LEWIS-PALMER SCHOOL DISTRICT No. 38 FILING NO. 1

A SUBDIVISION OF A PORTION OF THE SOUTH 1/2 OF SECTION 27, RANGE 67 WEST OF THE SIXTH PRINCIPAL MERIDIAN, COUNTY OF EL PASO, STATE OF COLORADO

AUGUST 31, 2022 Sheet 1 of 1

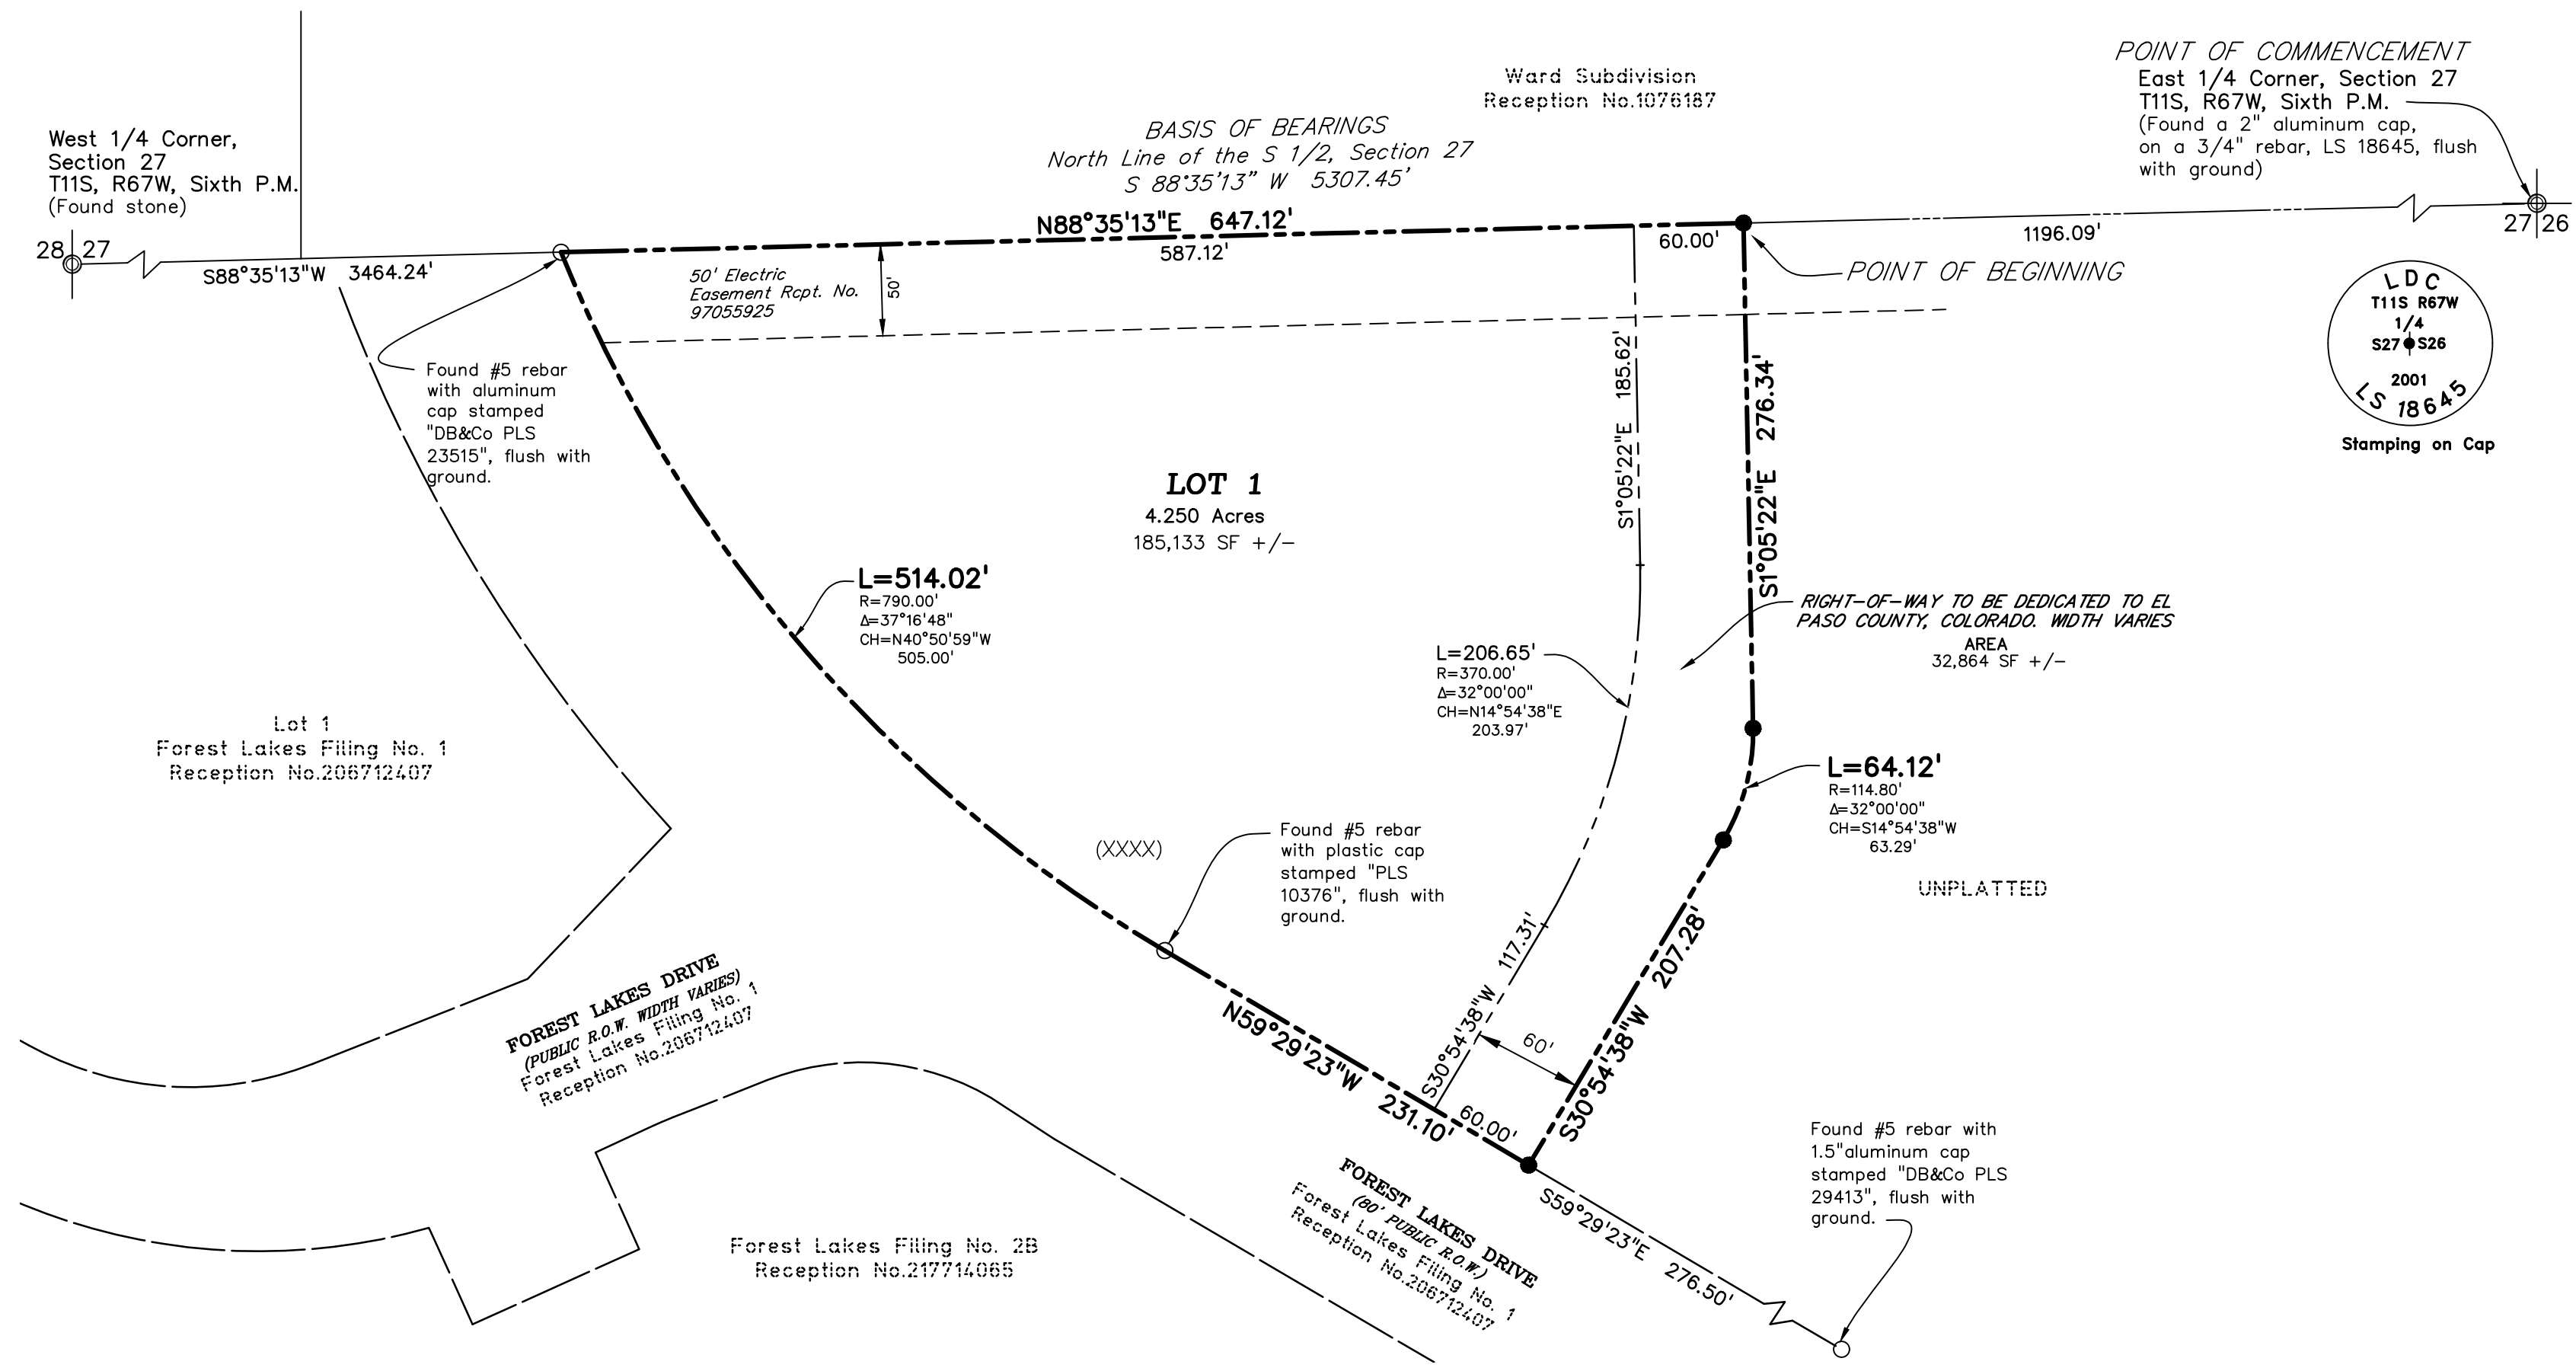
Comment not addressed from previous review. Please revise and address.
